# CITY OF PORTLAND, MAINE

**Project Name:** Munjoy Heights  
Six new buildings comprising 29 residential townhouses; one existing house on reconfigured lot

**Project ID:** 2013-228

**Project Address:** 79 Walnut Street

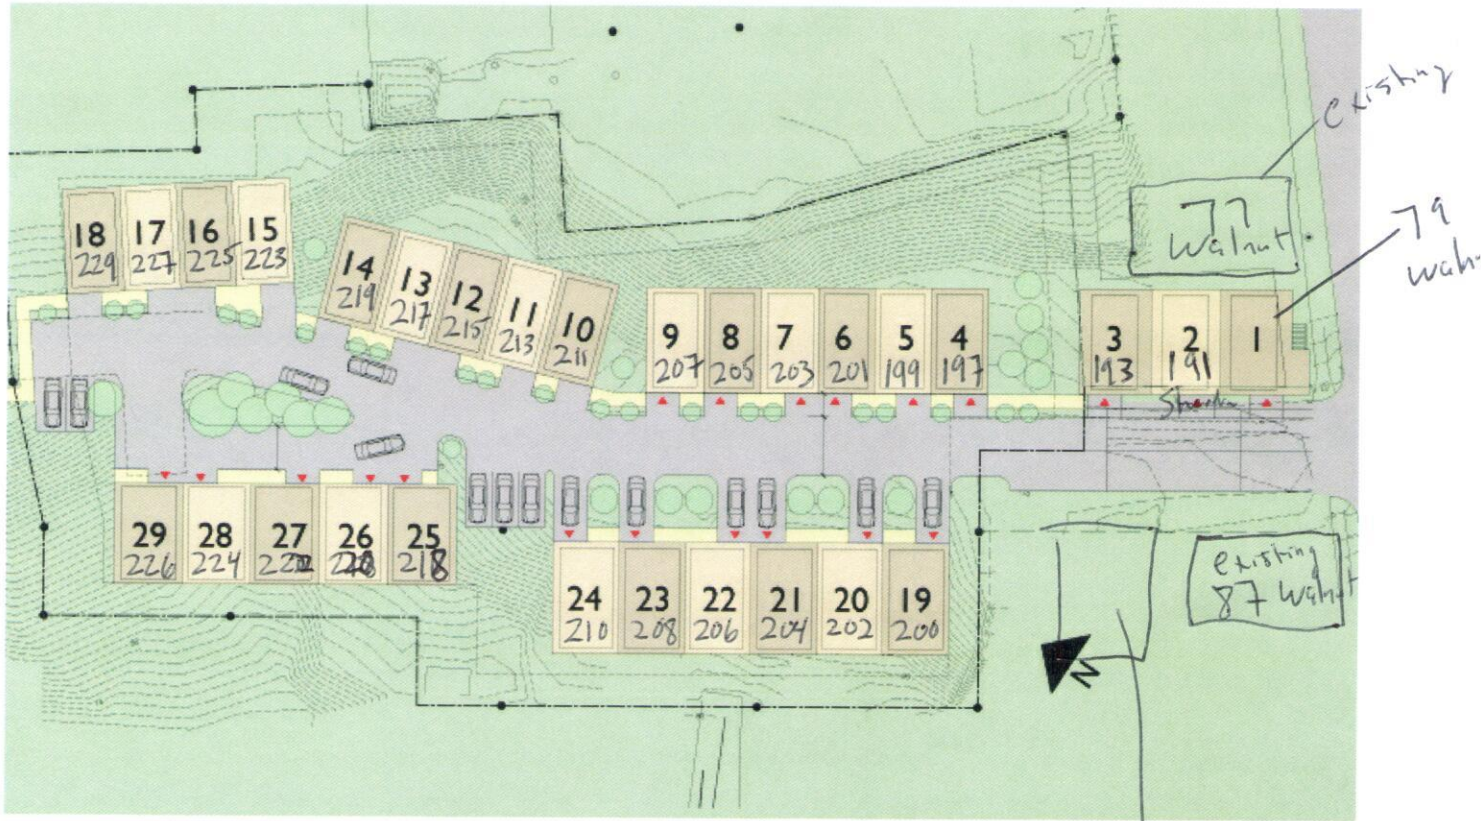
- vii. That the applicant shall have the proposed street addresses for the townhomes approved by the City E-911 Addressing Officer prior to the issuance of a certificate of occupancy; and
- viii. That the applicant shall submit additional lighting information to clarify whether the proposed site lighting (including building mounted lighting) meets the City's Technical Standards; and
- ix. All signage shall be subject to separate permits through the Inspections Division, with any traffic signage subject to view and approval by the Planning authority and Department of Public Services.

L2.0
 PLANTING PLAN

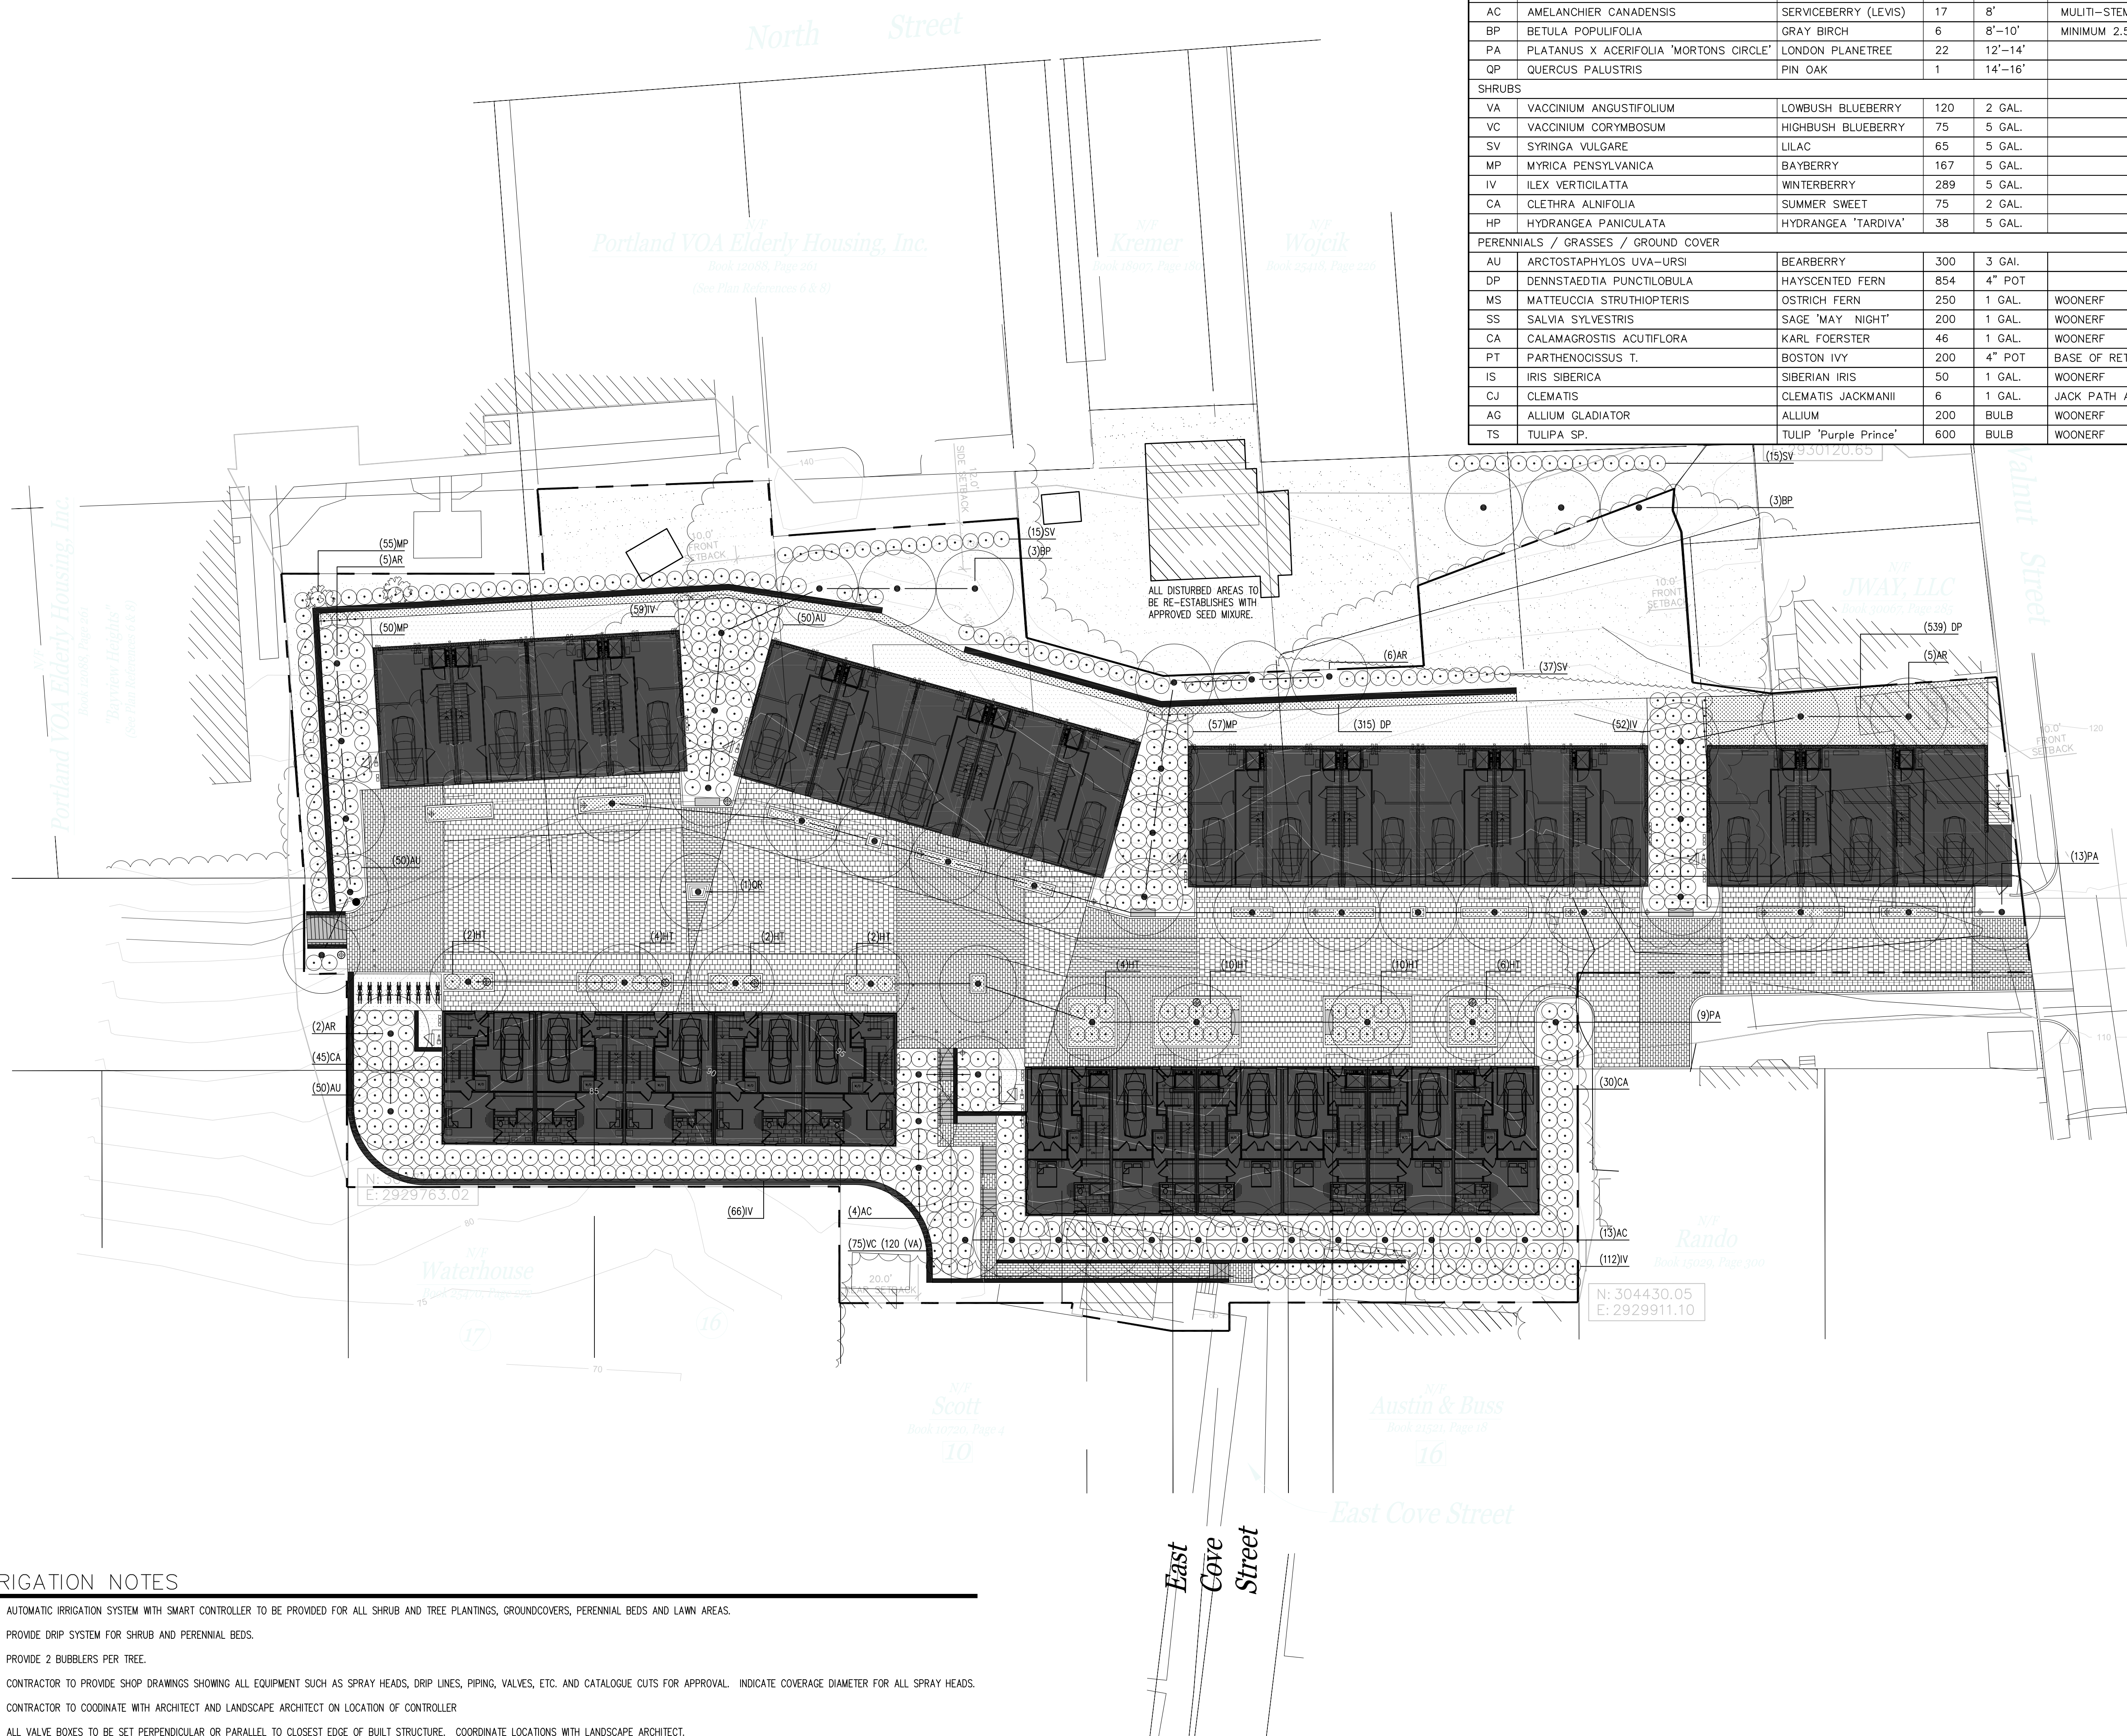
- Mitigation of the retaining wall and other impacts for abutters or where viewed directly by abutters;
  - Resolution of the Portland Trail node locations (ie where the stairs meet the access drive/parking area) so that the stairs enter the area via a dedicated pedestrian way and the trail is more visible (to address PT comments in letter dated 12.11.2013 and Traffic review comments dated 12.11.2013); and

- To address the City Arborist Jeff Tarling comments dated 12.12.2013 concerning planting material.
- iv. That the applicant shall provide illustrative material to show how the ramp leading to East Cove Street will appear to users and further discuss the design of this ramp with the City Arborist and Portland Trails to develop a design that meets Crime Prevention, safety and maintenance objectives, for review and approval by the Planning Authority prior to the issuance of a building permit; and

**a) Street-trees** - the project proposes 67 new trees ranging from Red Maple, London Planetree, 'Crimson Spire' Oak and Amelanchier. Approval Conditions would include the following: 27 Red Maple, 17 Amelanchier, 22 London Planetree, and one 'Crimson Spire Oak'. Recommendations: select Maple cultivar such as 'Redpointe', 'Karpick', 'Bowhall' Red Maple, the Amelanchier proposed is a good native species with wildlife values, London Planetree is the main tree planted throughout the 'Woonerf' (22 trees), unfortunately this species is on the edge of its range here in Portland. On Spring and Danforth Street most of the London Plantrees planted in the late 1970's have declined do to 'frost cracks' or the freeze / thaw cycle caused by late Winter fluctuating temperature. Since Planetrees present some risk of survival, either an alternative species or a 5 year guarantee of replacement should be considered. Several of the 'Woonerf' tree planters are sub standard in size due to space restrictions. These include: between lots 6-7, 12-13, near the parking spaces and center island. These trees planted in the Woonerf and between driveways are risky places to plant trees and have them survive especially in Northern climes with snow storage and deicing salts. Recommend removing these four trees or extending the replacement guarantee to five years and or insure the paving / landscape will be improved and vacant tree wells repaired.

\* Reduce 4 of the London Planetrees in 'Woonerf' due to limited root zone, planter space and / or extend replacement to five years.

- \* Shrub planting - Upgrade the Bearberry (AU) from 1 Gallon to 3 Gallon plant size to ensure greater coverage,
- \* ALL plant types and sizes MUST contain quantities recently shown as "TBO" on a final landscape plan.
